Consultee Comments for Planning Application 21/01323/FUH

Application Number: 21/01323/FUH

Address: 193 Birmingham Road Shenstone Woodend Lichfield Staffordshire WS14 0PA

Proposal: Erect a three meter high acoustic fence around the perimeter of the property

Revision date: Revision: Plan No: PLA002
Title: Existing and proposed plan and elevations

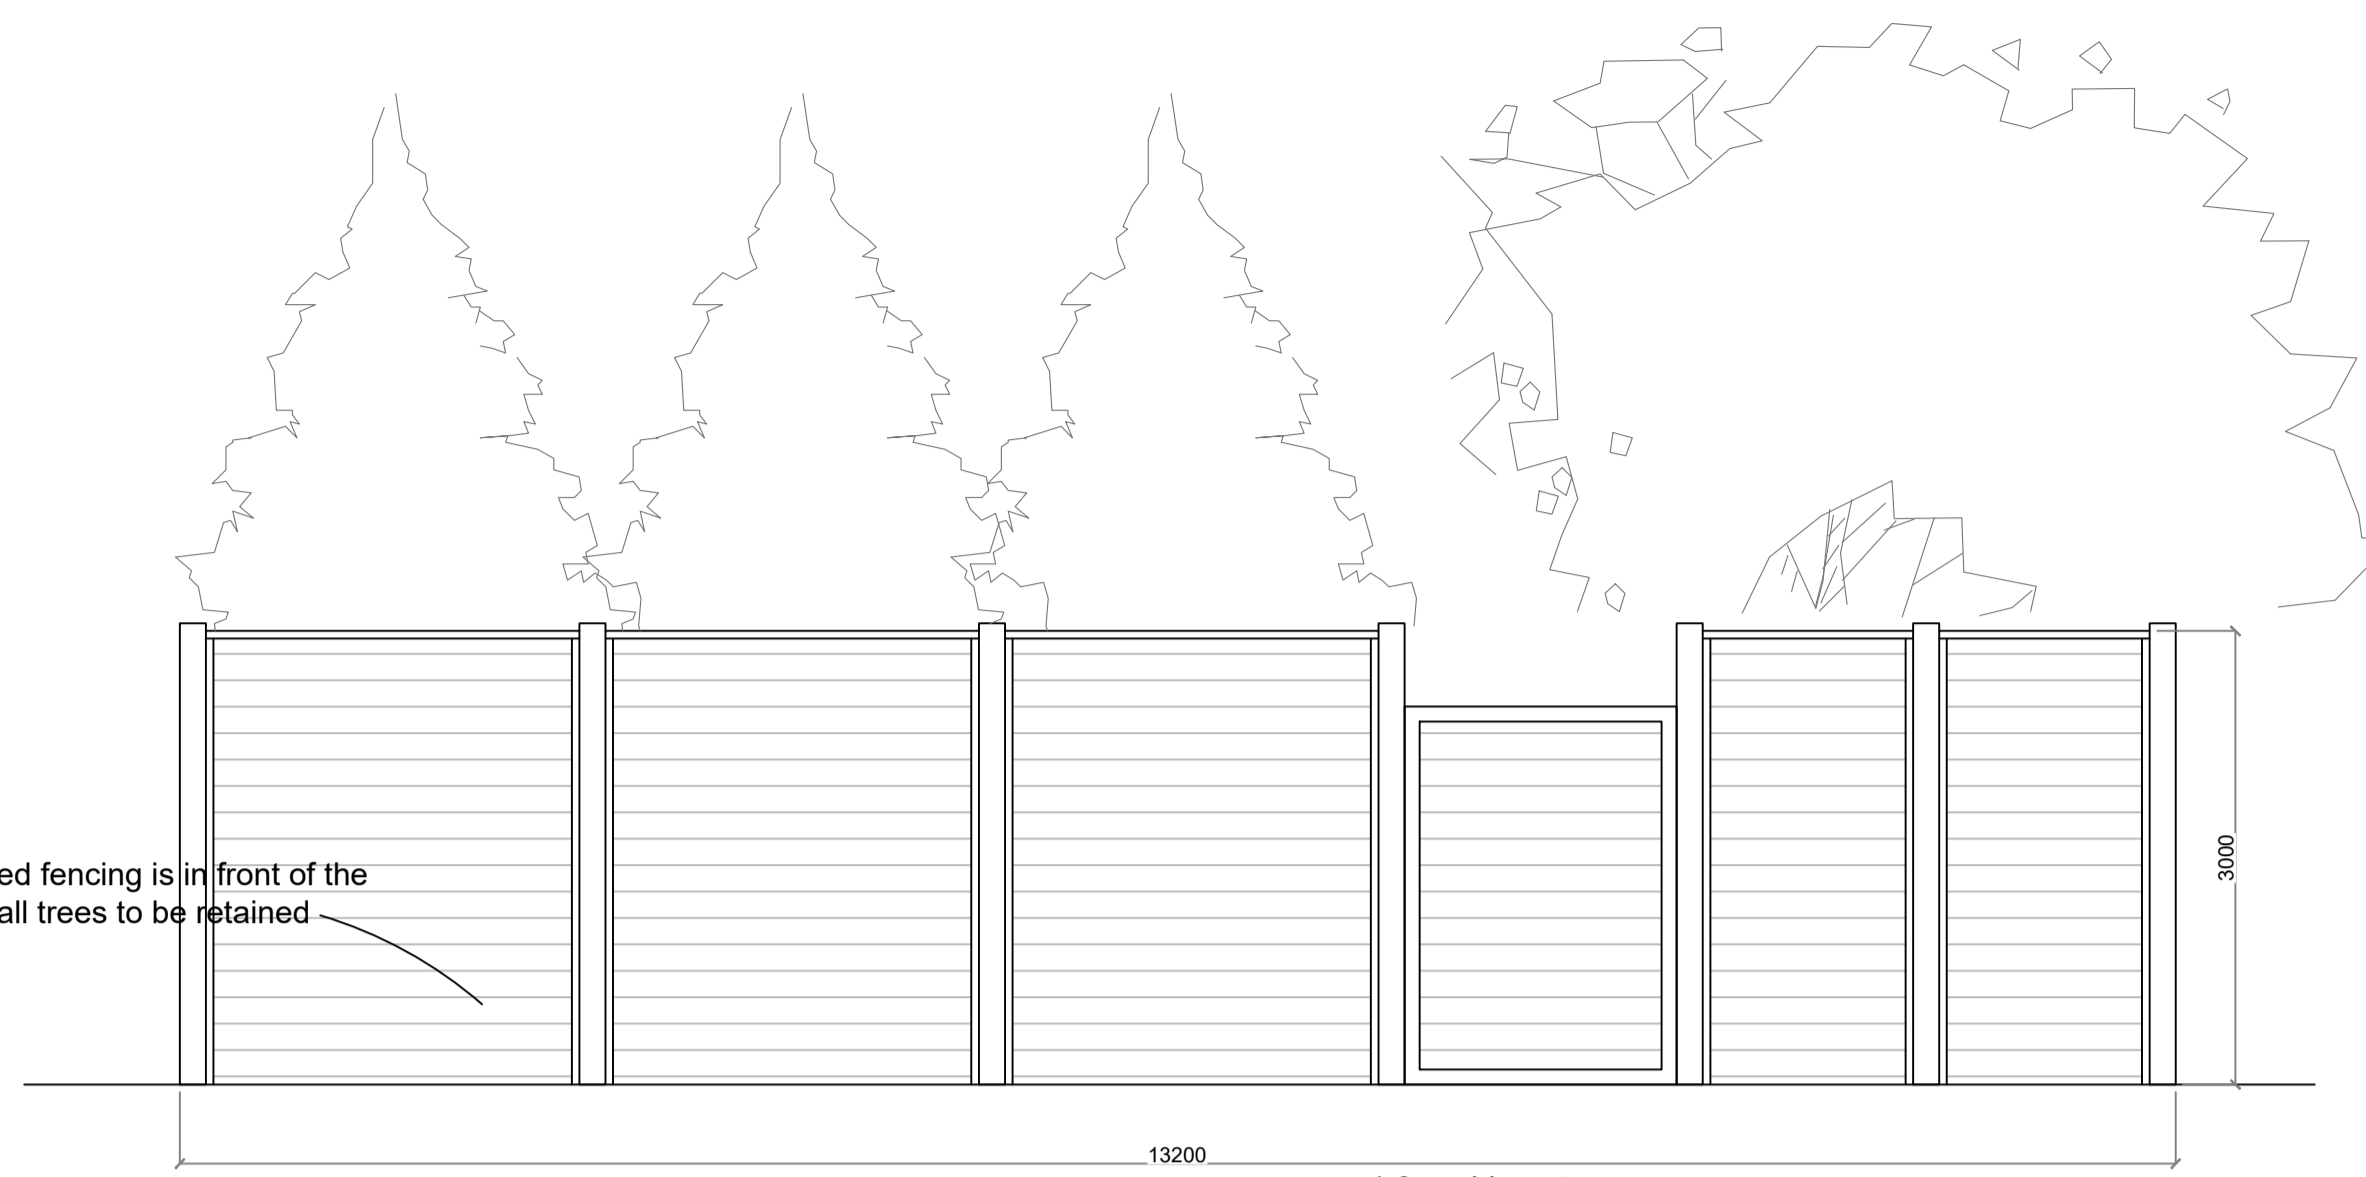
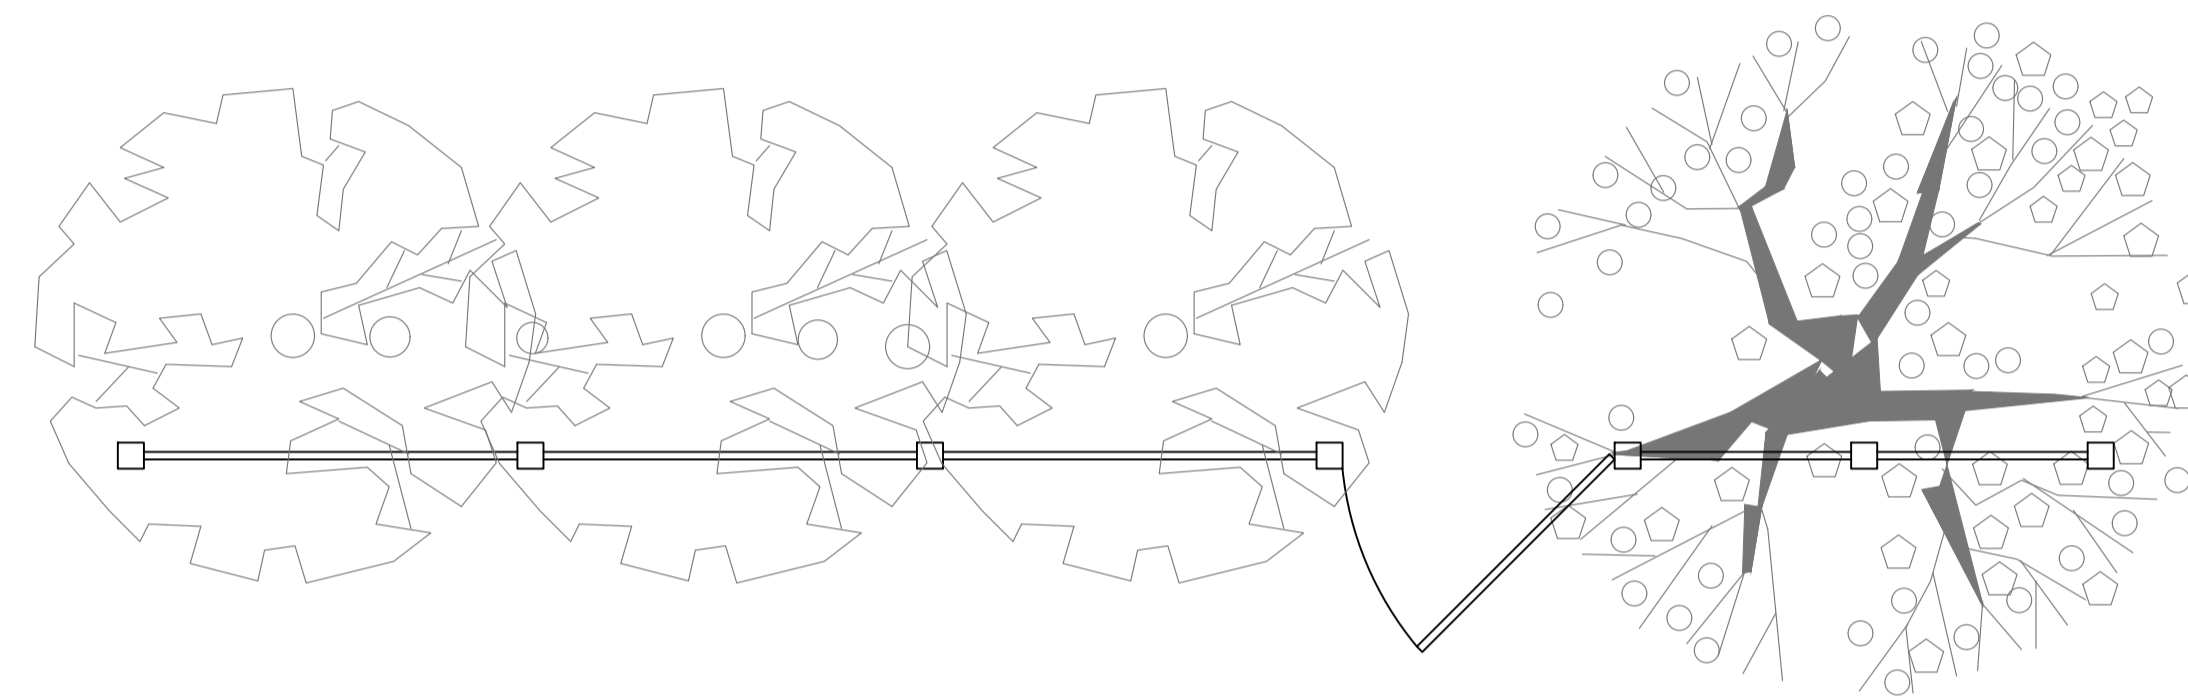
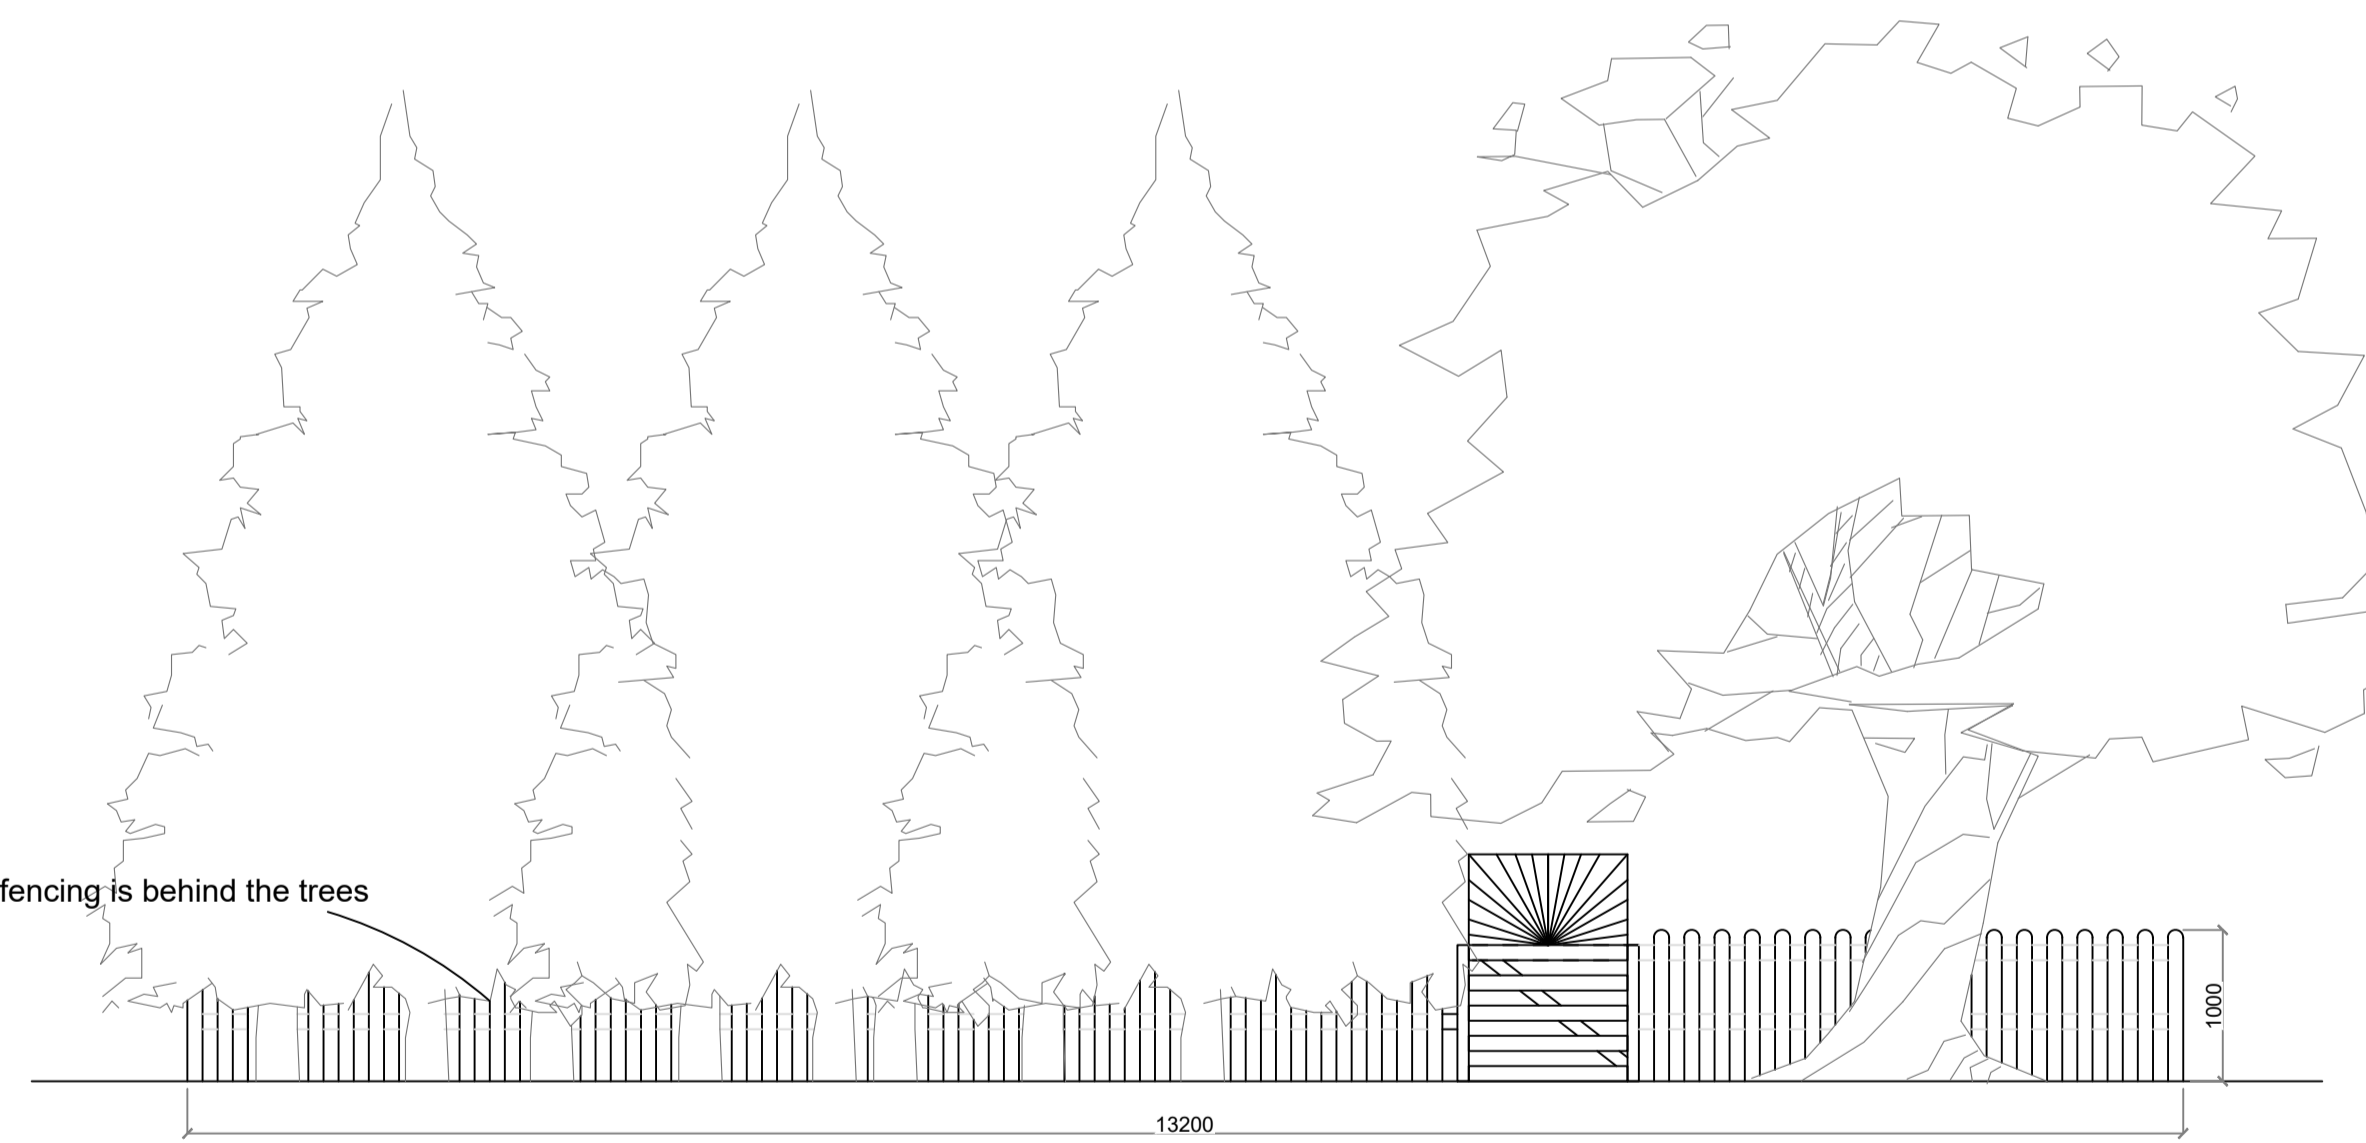
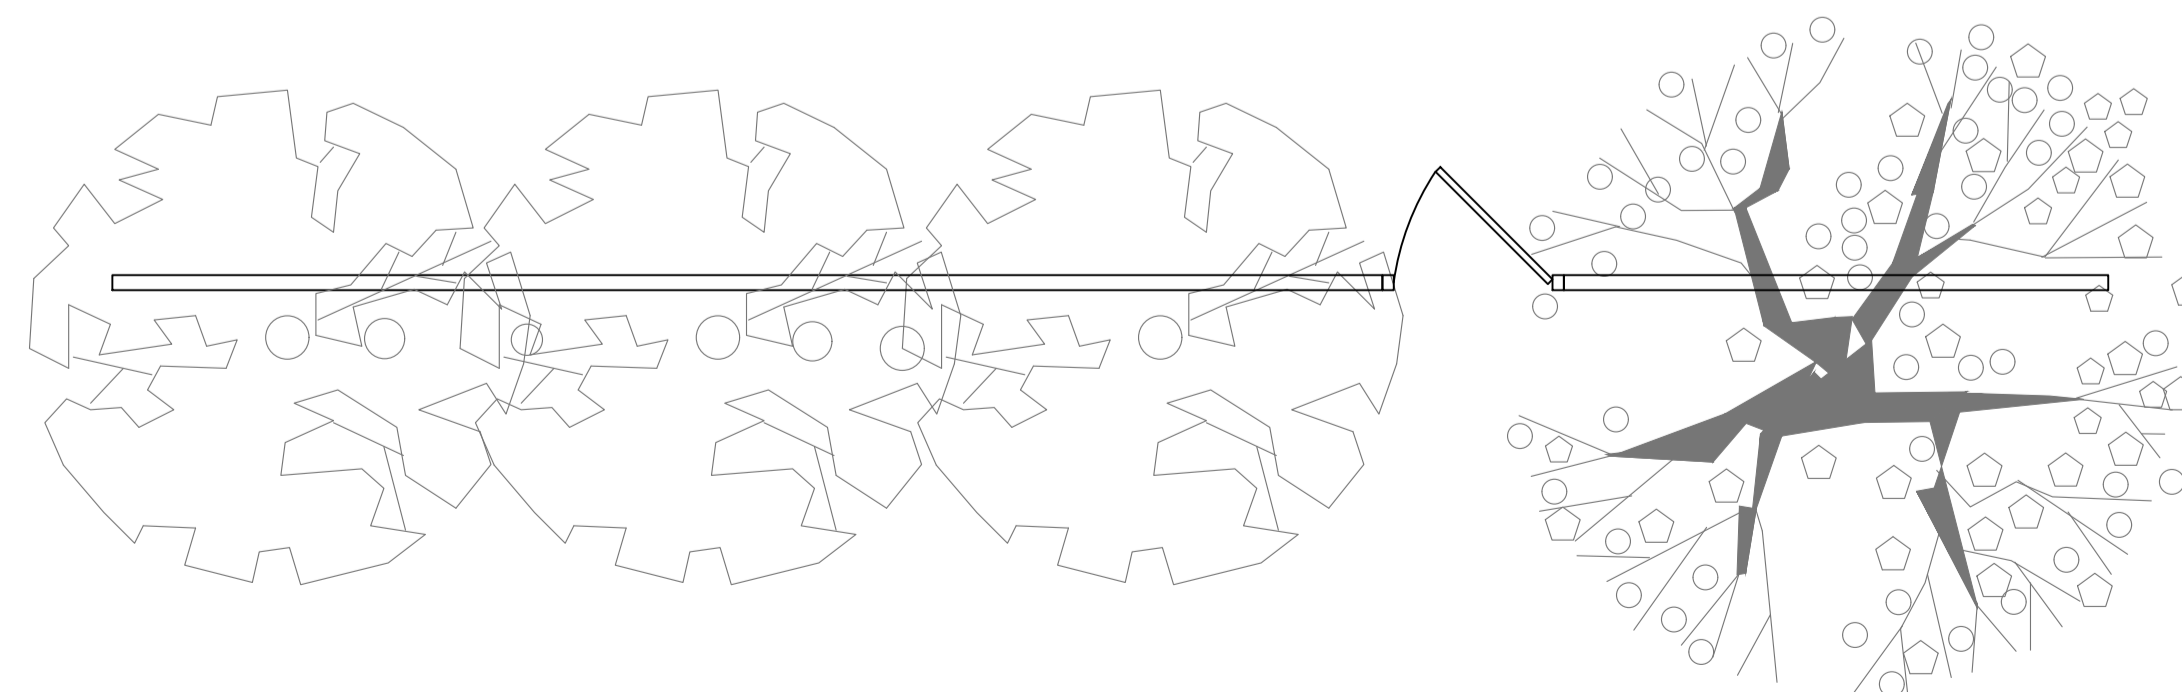
Whilst the site is not within any designated conservation area and currently there are no TPO's, it does appear that there are a number of trees/hedges affected.

Having said this we do not consider the need for a tree report given the nature of the hedge. If you were minded to approve this application, we would ask for a tree retention condition to be applied to any permission that may be forthcoming.
